COUNTY OF EL PASO, STATE OF COLORADO
GRADING AND EROSION CONTROL PLANS
DECEMBER 2021

Reviewed by:
Glenn Reese, P.E.
Stormwater Engineer II
GlennReese@ElPasoCo.com
719-675-2654

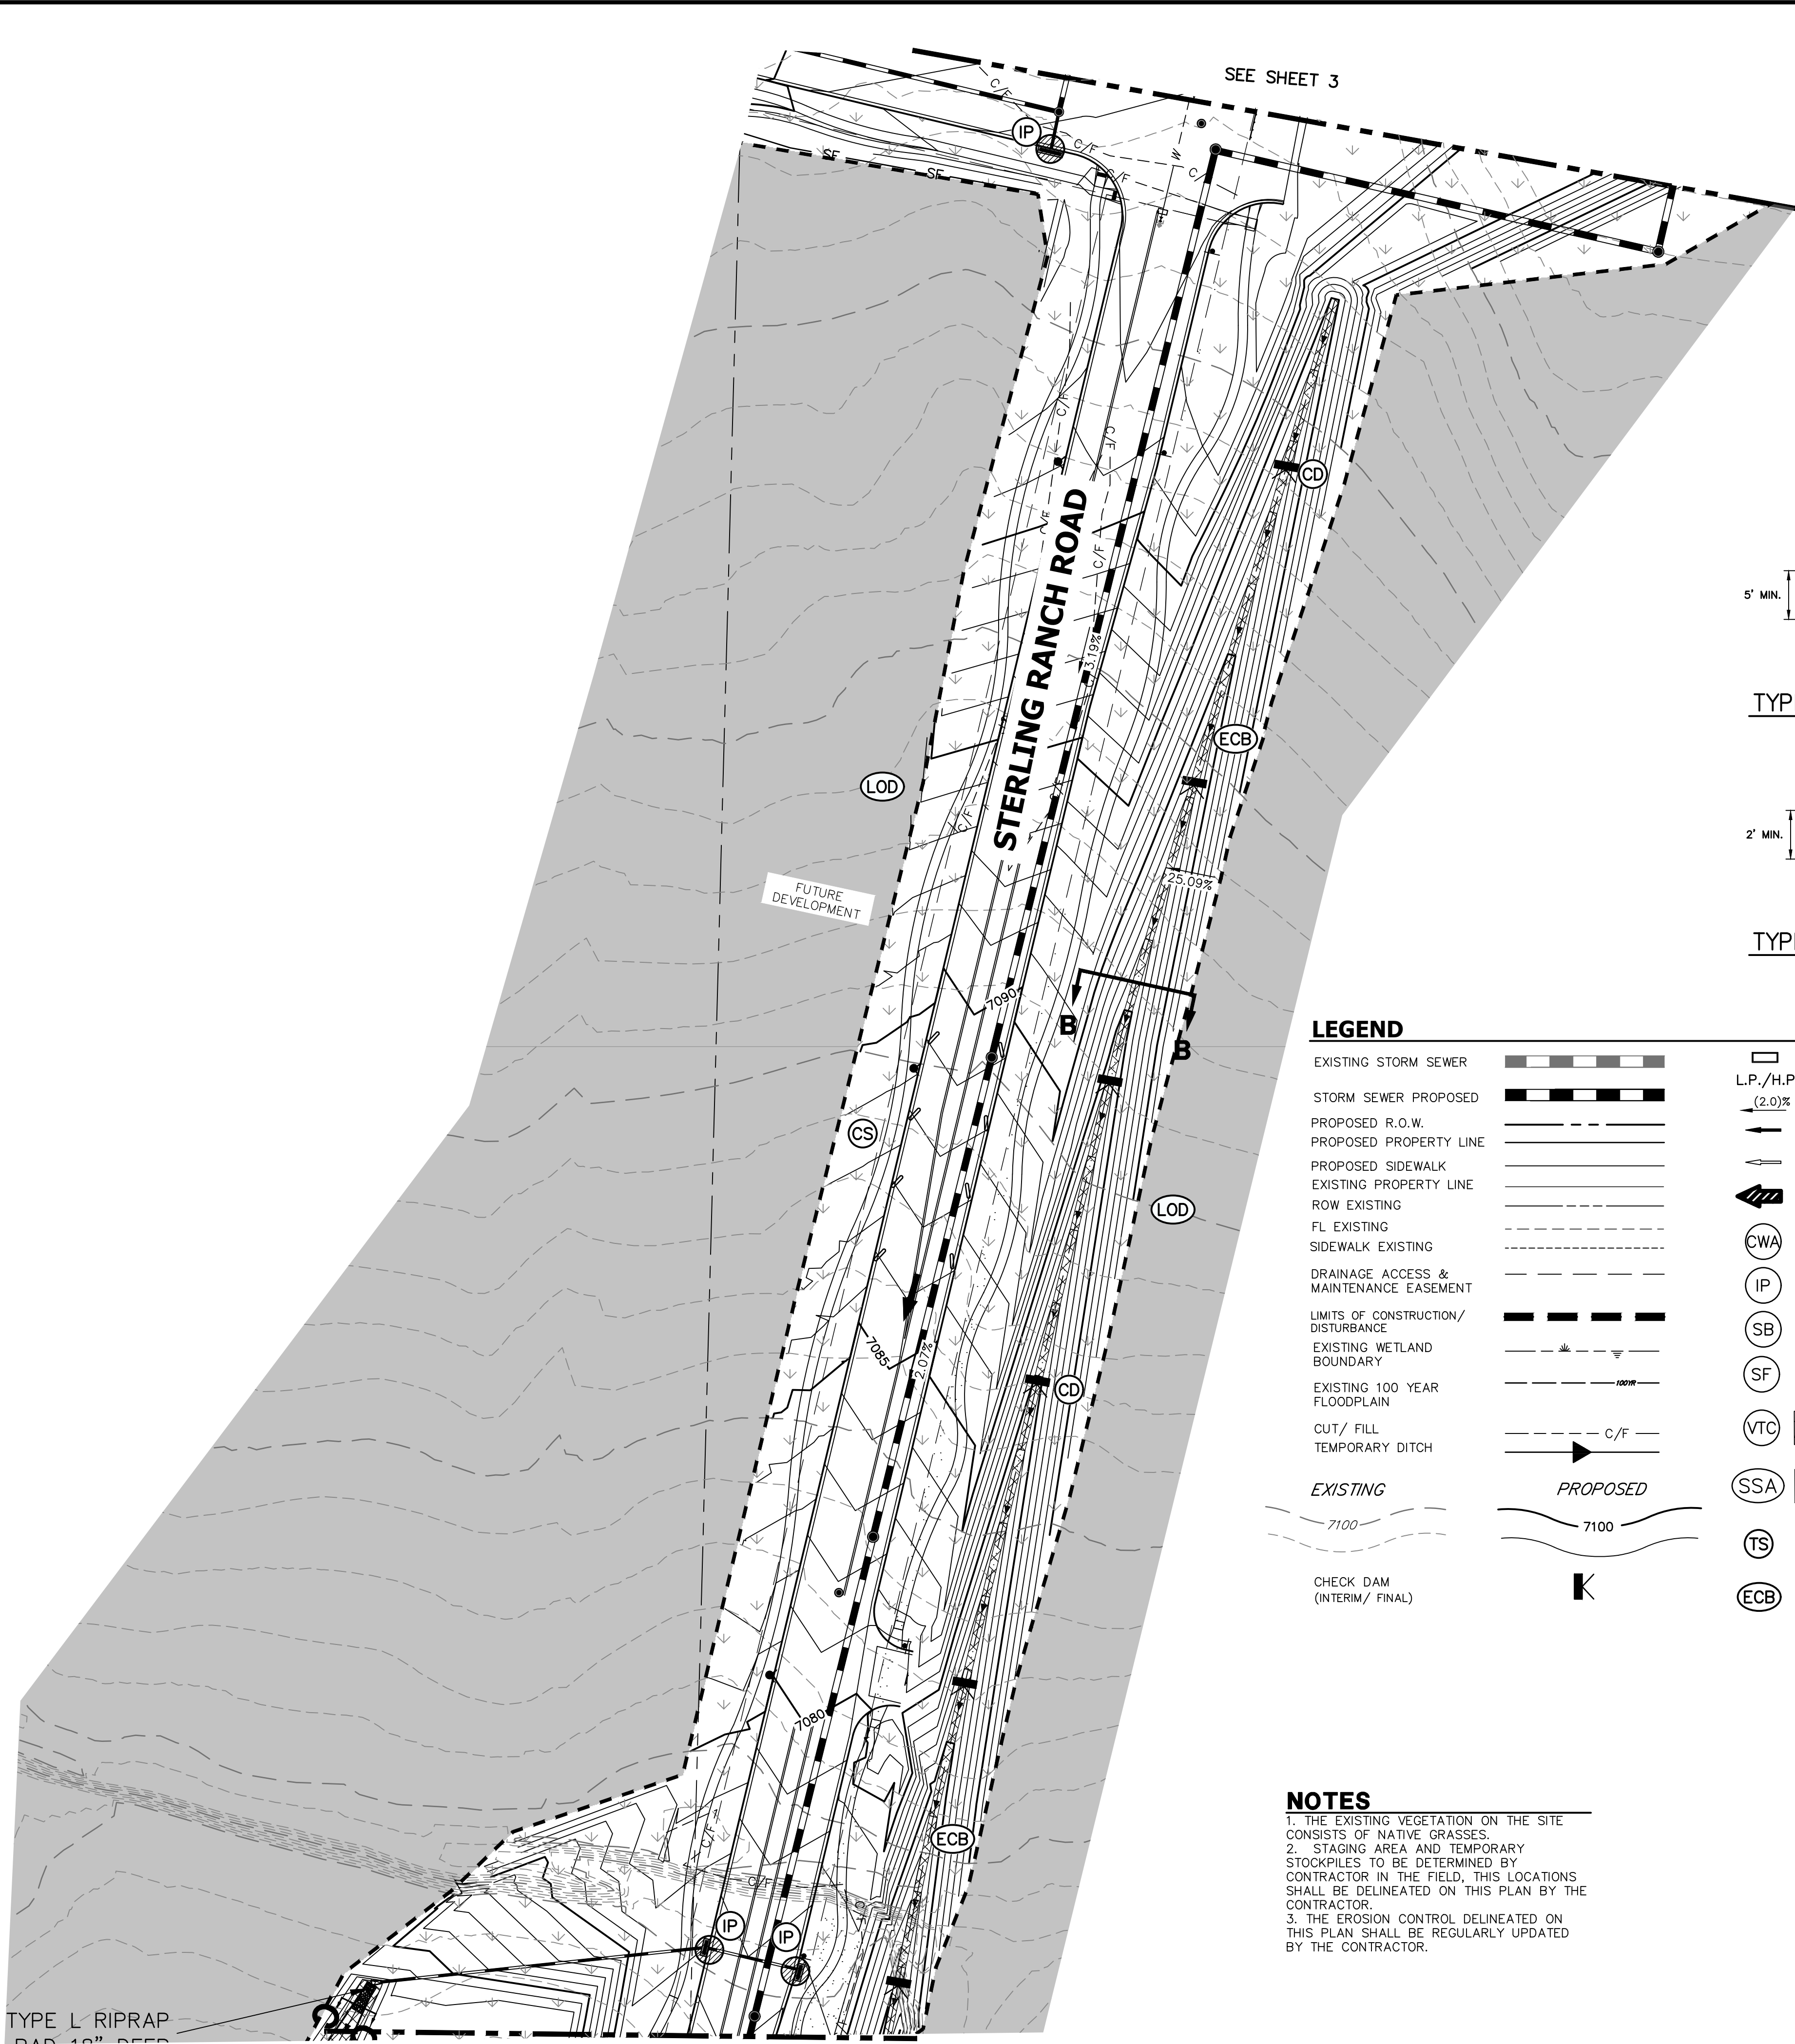
- Rock check dams shown on FAE Form. Show them on plans here and in Legend below.

add a column next to BMPs to label each as "initial," "interim," and "final" or create a separate table.

Label as a Section or should there be mirrored arrows on the other side of the bridge like bridge on Sht 6??

Missing access along channel, as shown on drainage plans. Please add Address how steep grading will work with access coming off of BGP

label grade of steeper slopes throughout site.

show locations on plans, or make note that location is TBD by contractor.

revise to "seeding and mulching?" Mulching shown on FAE form.

show locations on plans

- GEC Checklist Item "B" - label adjacent subdivisions.
- Item "I" - discuss existing vegetation in a note.
- Item "S" - show drainage flow arrows on plans and legend.
- Item "U" - show location of staging and stockpiles on plans.
If locations are TBD, note this on plans.

label major contours

JR Response: Addressed

JR Response: Addressed

JR Response: Addressed, added mirrored arrows

JR Response: Addressed

JR Response: Addressed

JR Response: Addressed

JR Response:Addressed

JR Response: Addressed

JR Response: Addressed

JR Response: Addressed

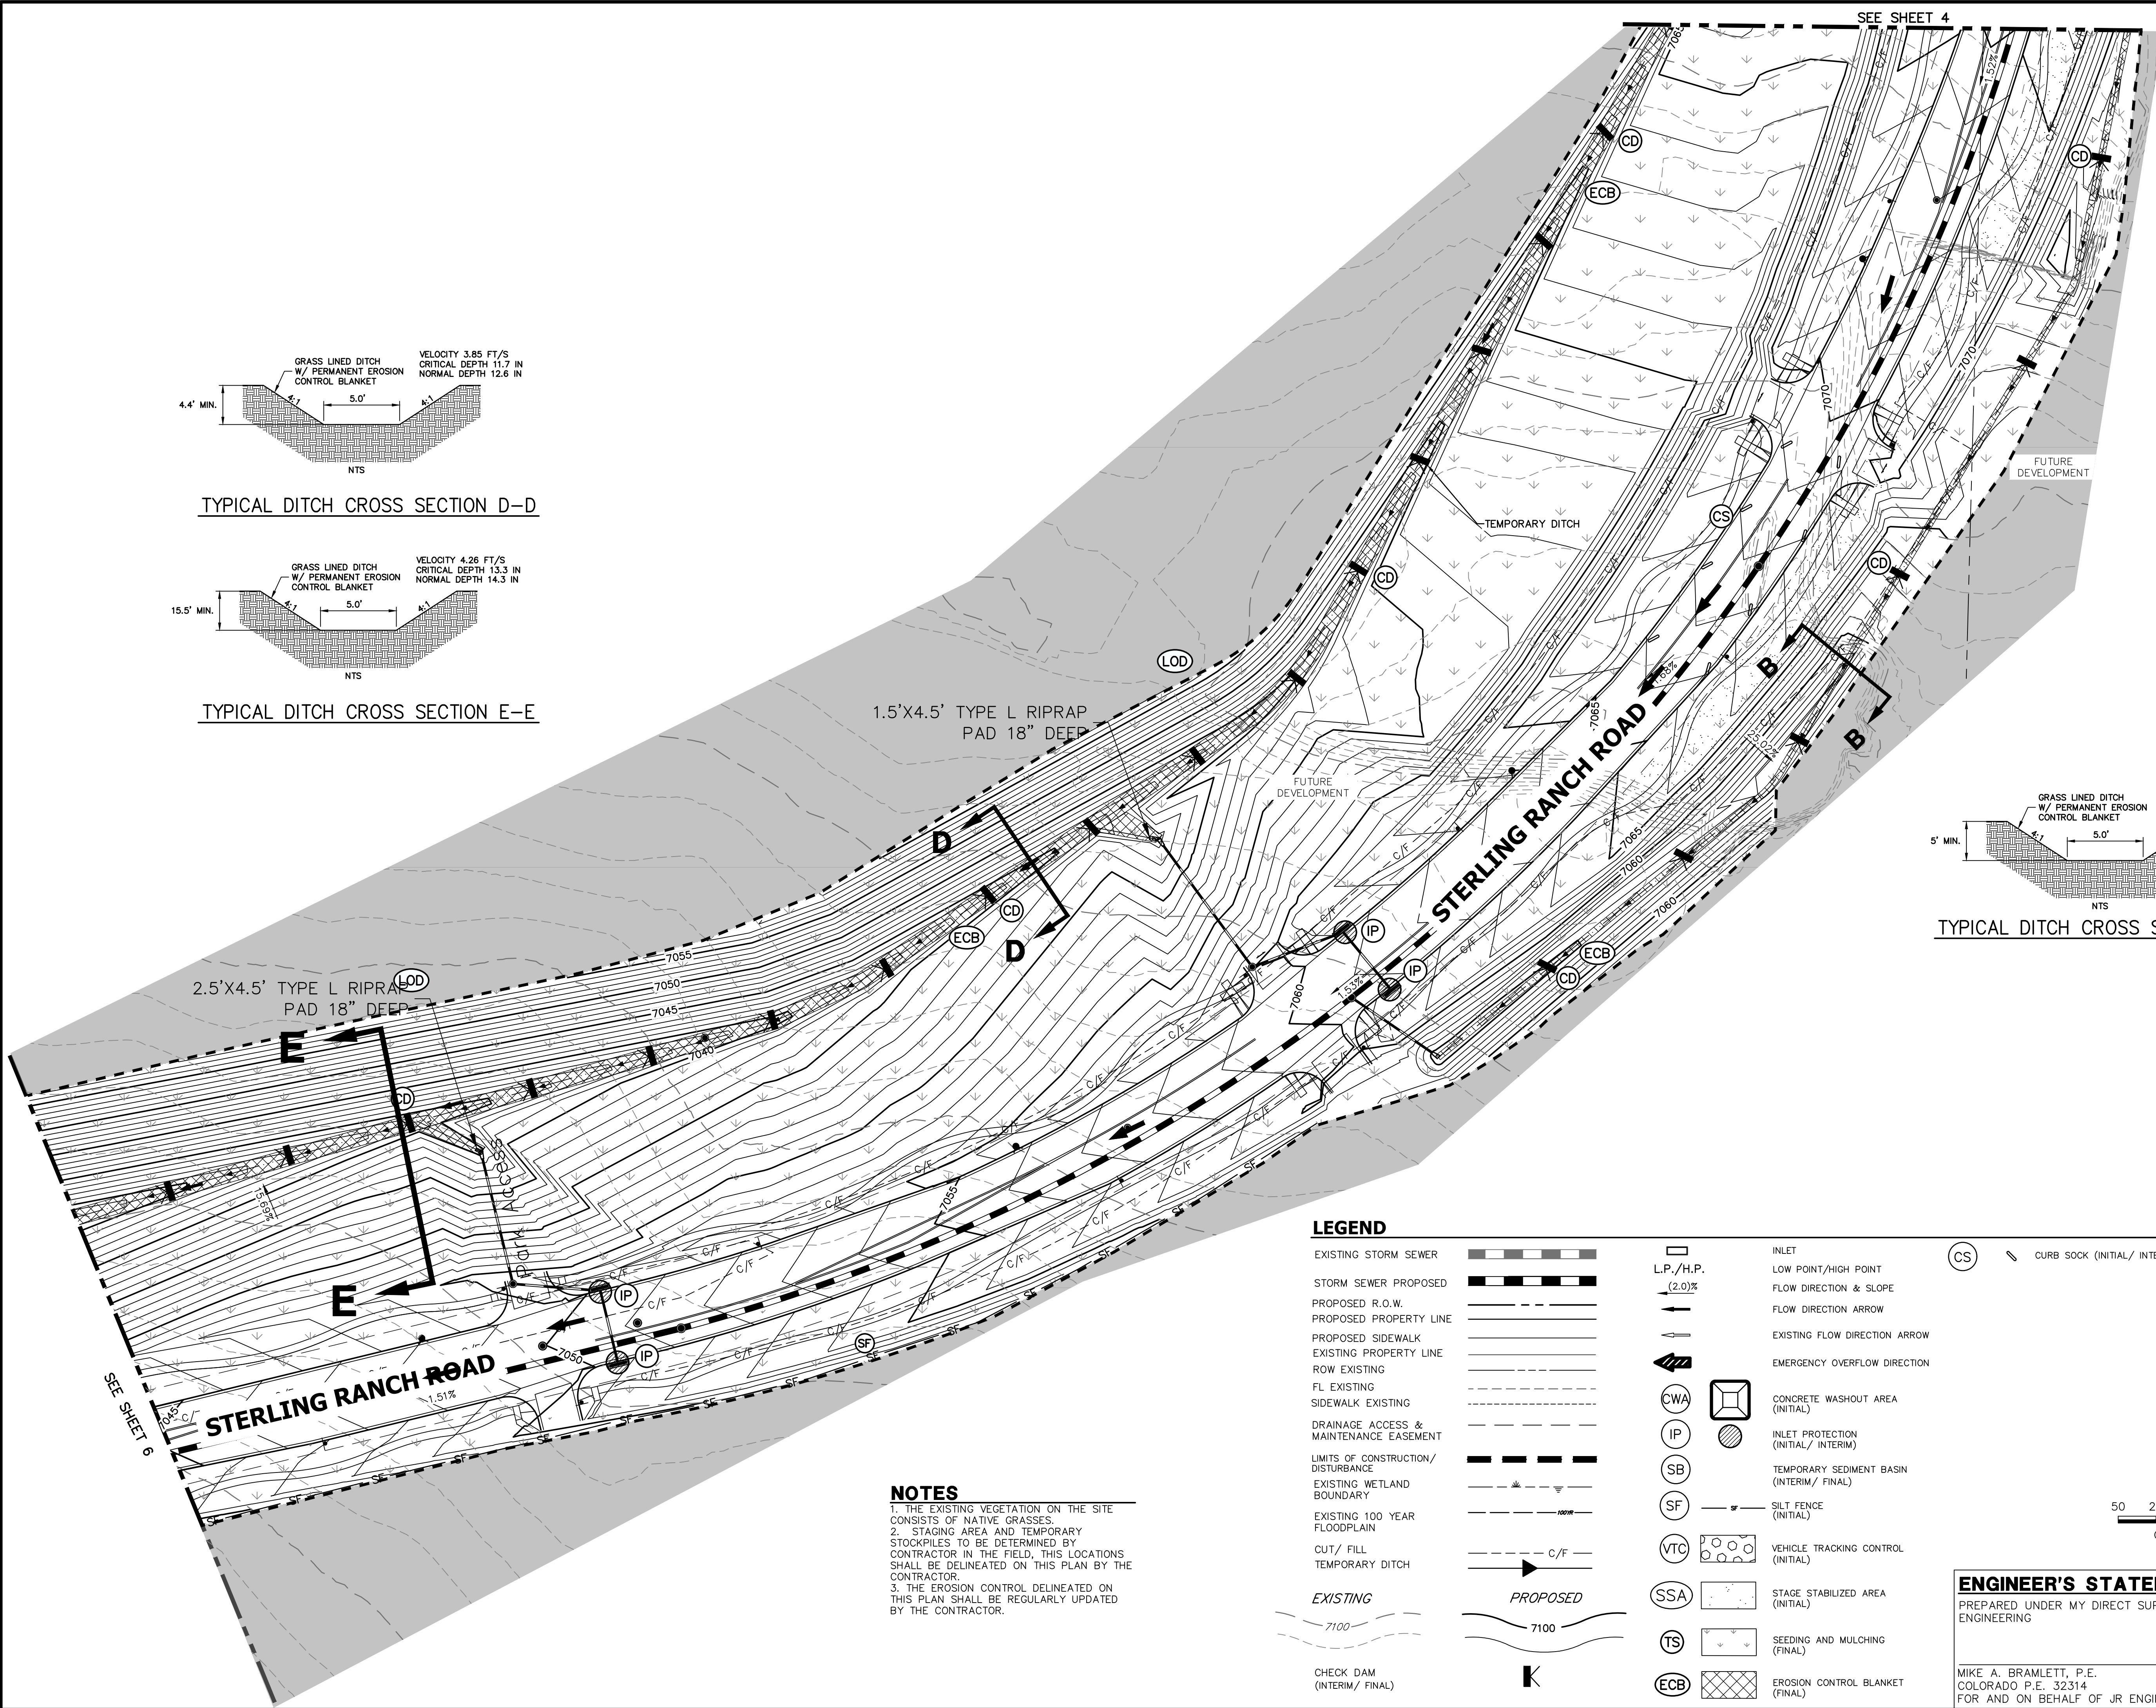
Check if we are able to remove superelevation through the curve.
JR Response: superelevated per criteria

Provide swale section
JR Response: Addressed

label major contours

label and provide detailed info for TSB and EDB (forebay(s), tickle channel, maintenance access road, etc).

Show erosion protection on spillway.

Label as Section D-D?

Channel section does not match design section in Dr letter. Please update Label and show section locations to match those on drainage plan.

JR Response: Addressed

JR Response: Addressed

JR Response: Addressed

JR Response: Addressed

JR Response: Addressed, cross sections updated to match drainage letter
